OXFORDSHIRE COUNTY COUNCIL'S RESPONSE TO CONSULTATION ON THE FOLLOWING DEVELOPMENT PROPOSAL

Application no: 22/02866/OUT

Proposal: OUTLINE planning application for up to 120 dwellings, vehicular and pedestrian access off Ploughley Road, new pedestrian access to West Hawthorn Road, surface water drainage, foul water drainage, landscaping, public open space, biodiversity and associated infrastructure. Access off Ploughley Road is not reserved for future consideration

Location: Land East Of, Ploughley Road, Ambrosden

TRAFFIC CALMING PLAN  
SCALE 1:100

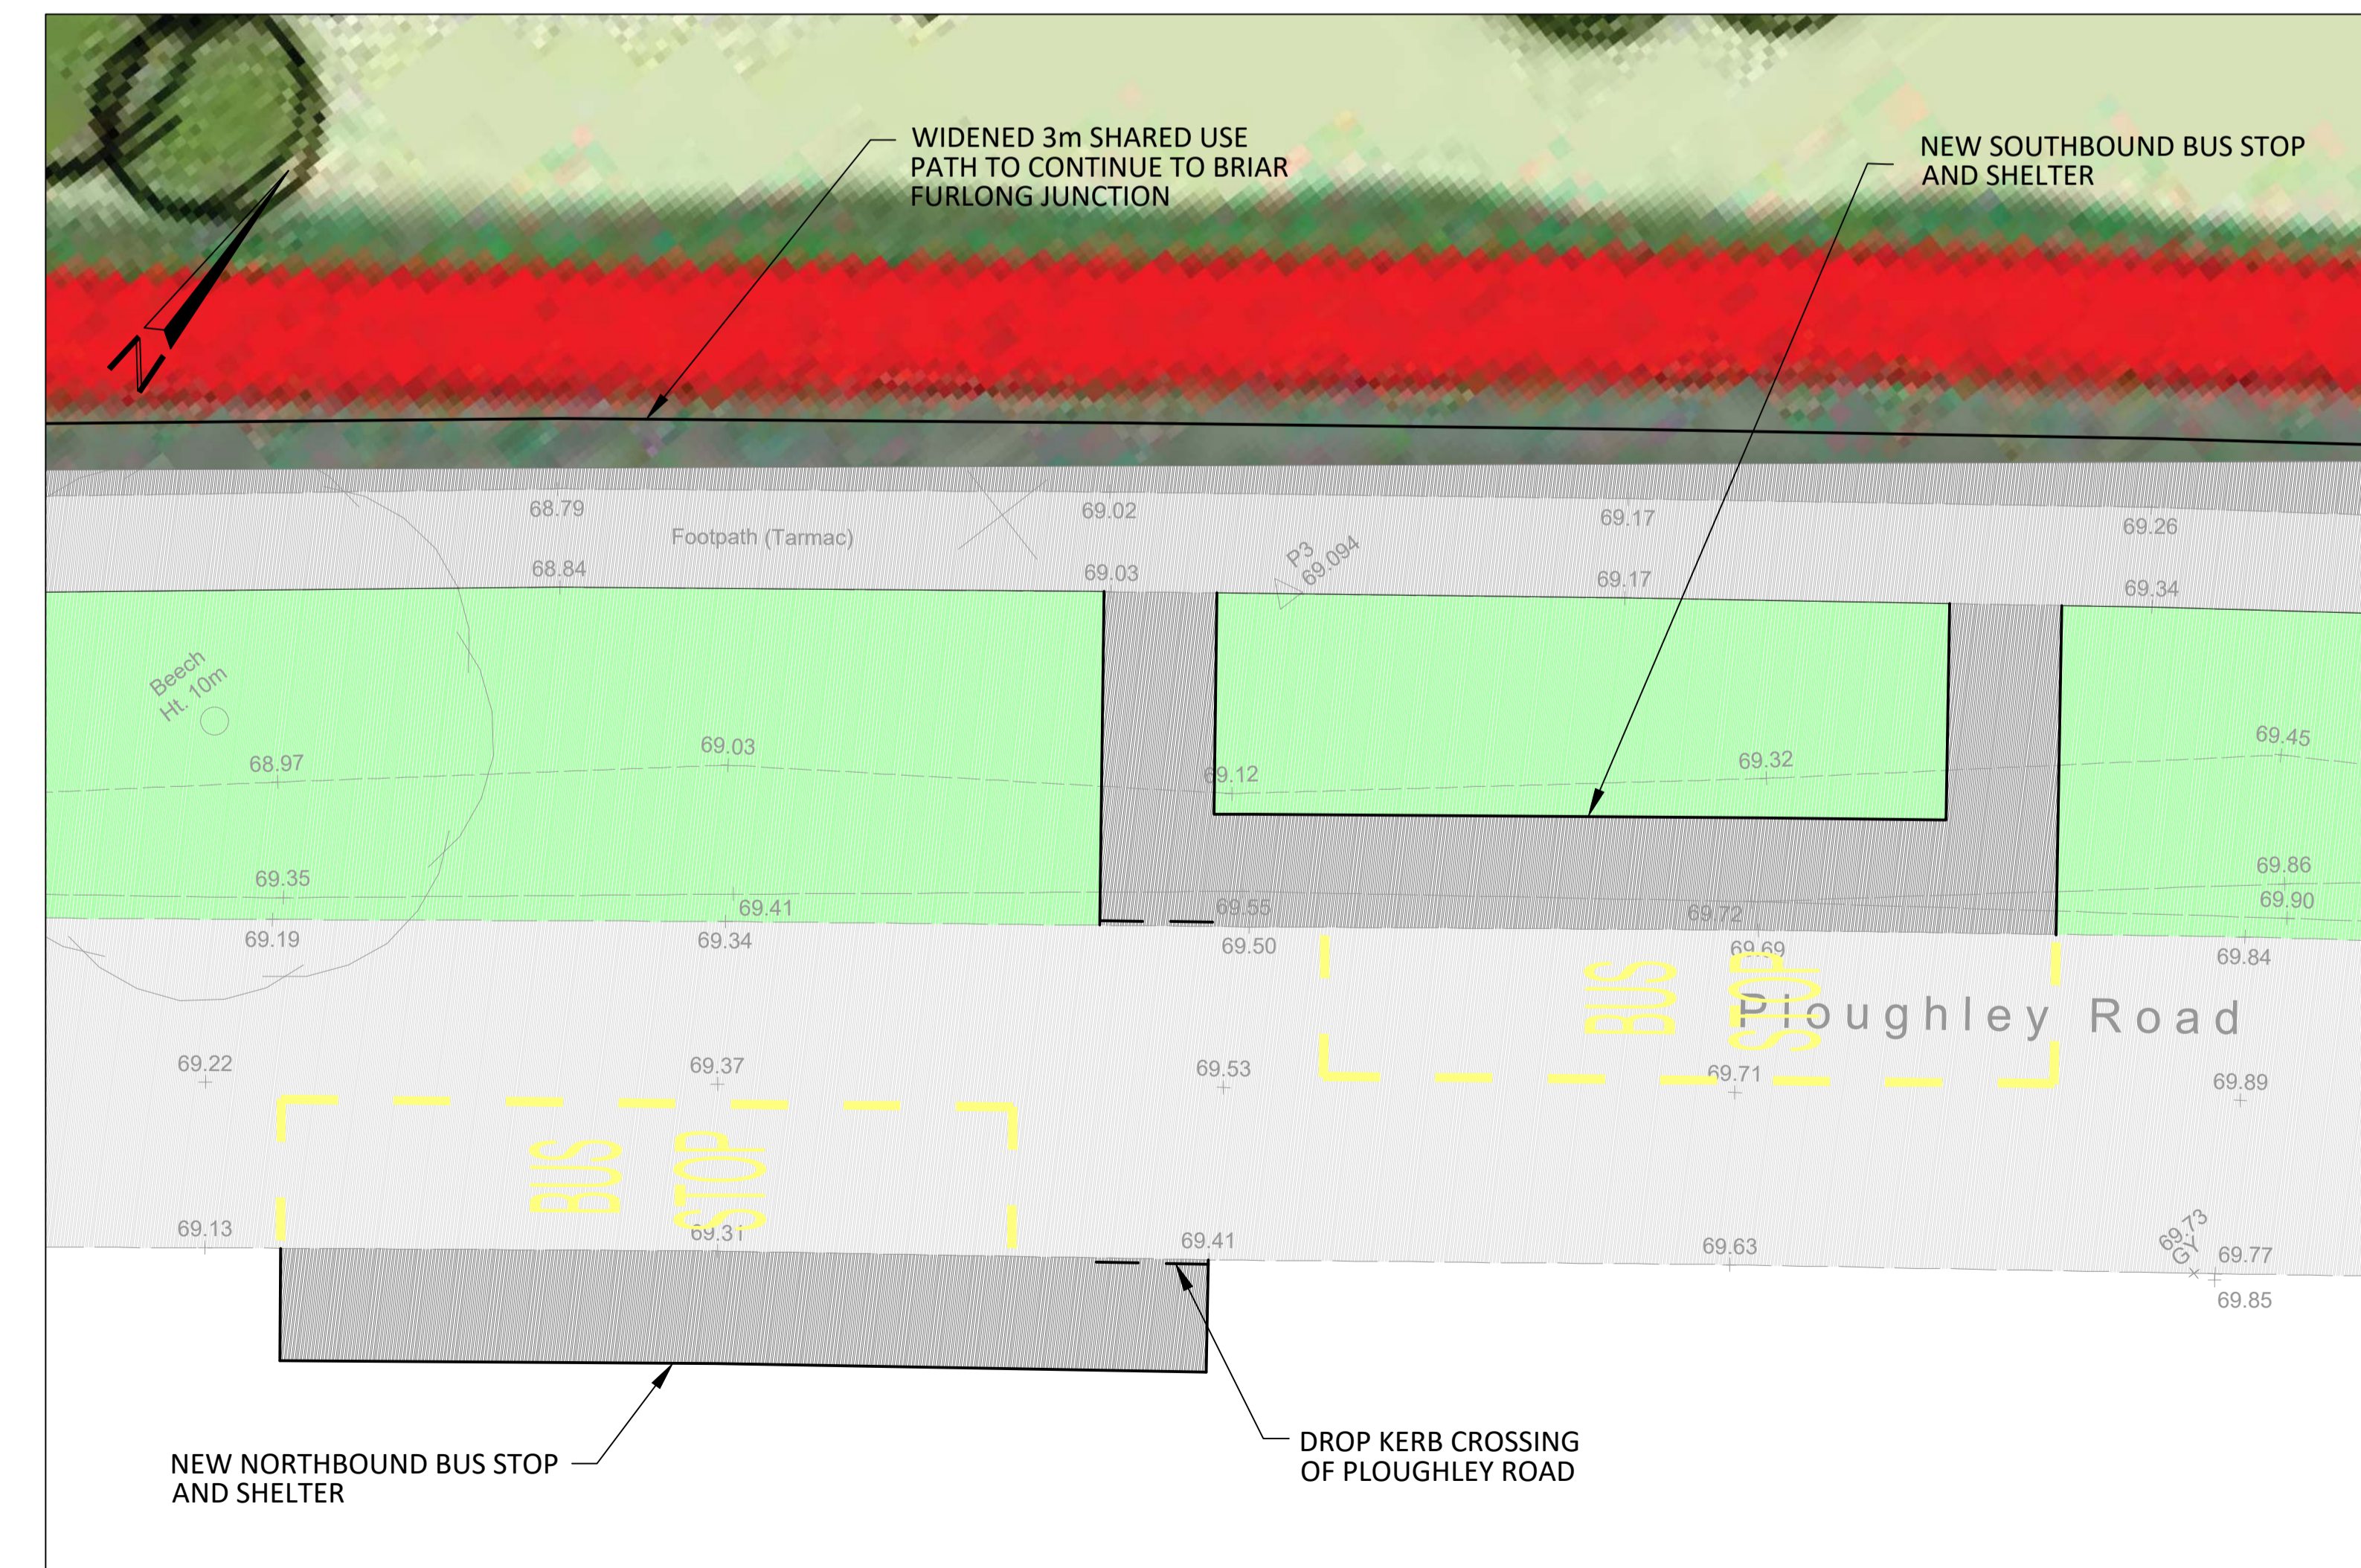
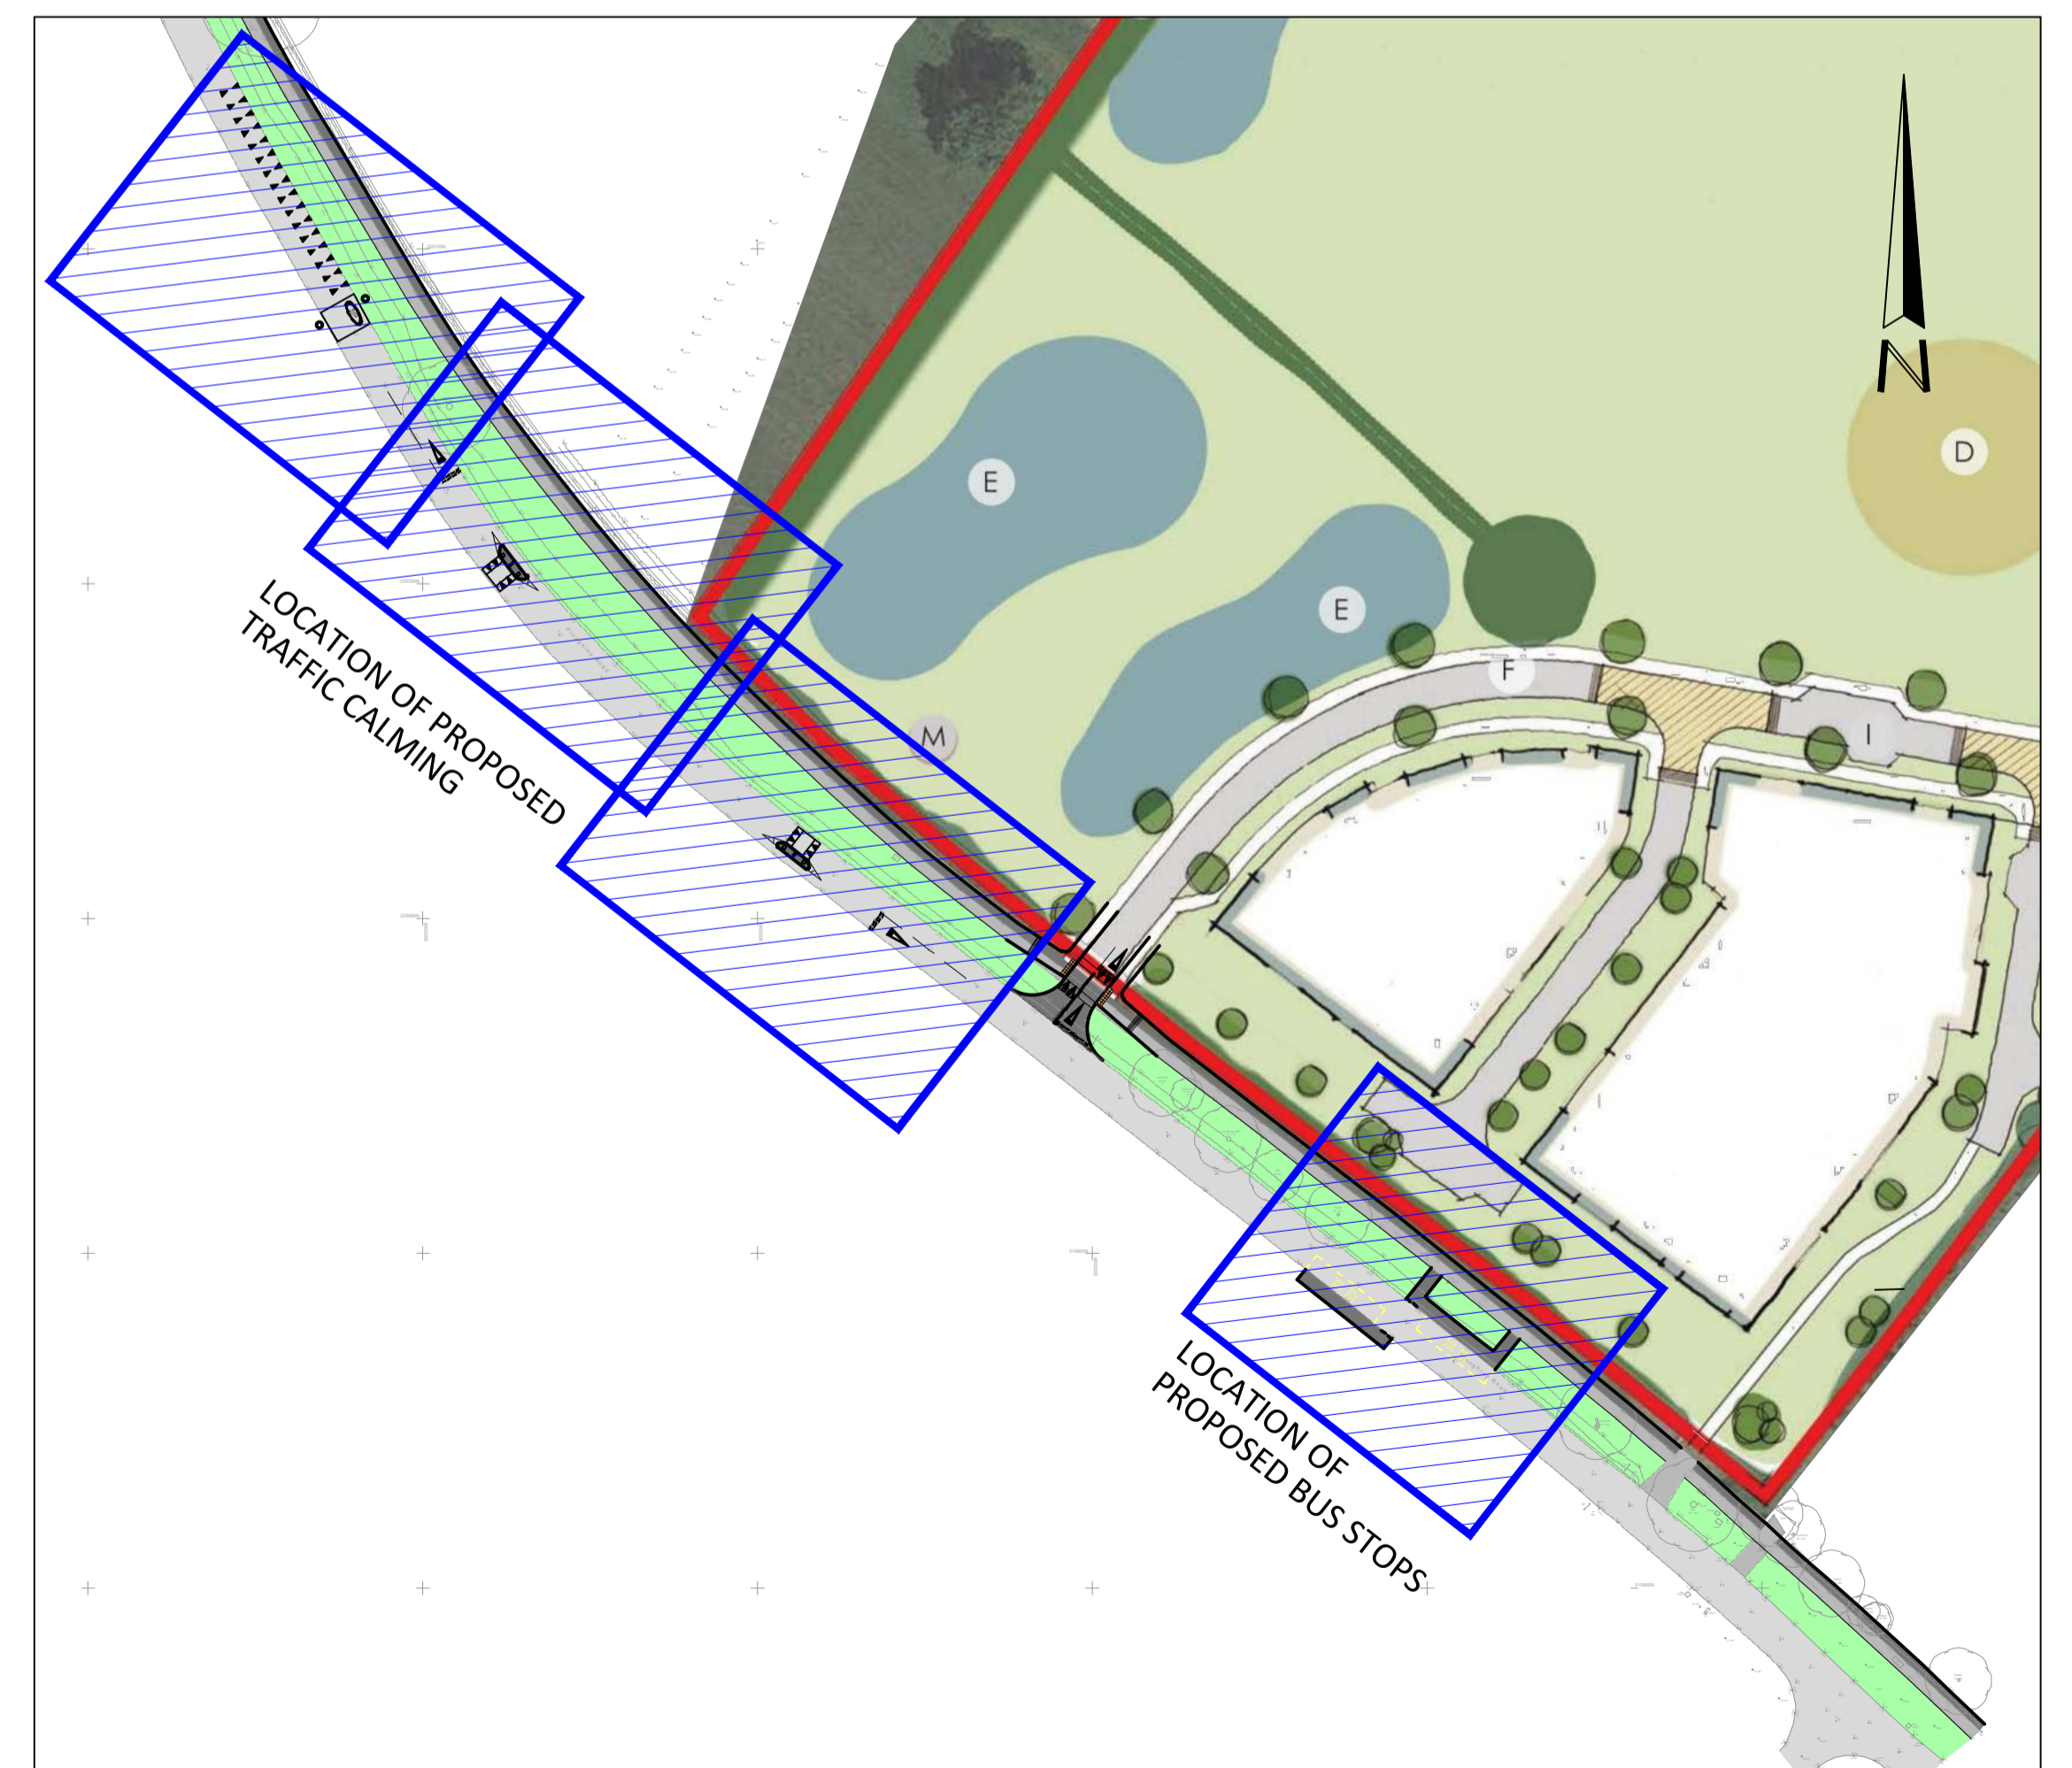
A similar proposal adjacent to the site may be appropriate. If the application is to be approved, OCC require suitable traffic-calming measures to be provided as part of the S278 works. Any features must be designed to accommodate oversize military vehicles and large agricultural plant, and any vertical deflections along a bus route are subject to agreement with the bus operators.

Section 9.3 of the Transport Assessment makes reference to bus stop infrastructure improvements, which are welcomed. The majority of the development is in excess of 400 metres from the existing bus stops and new stops should be provided in proximity to the vehicle access from the development as part of highway works undertaken by the developer. These stops should be provided with a two-bay shelter and Premium standard pole, flag and timetable case – specifications can be obtained from the Council at the appropriate time. The shelter should be RTI-ready i.e. include electrical connections for a future real time information screen.

A crossing point will be required to ensure a safe pedestrian route across Ploughley Road to the northbound bus stop. It is envisaged that this could be incorporated into one of the traffic-calming features.
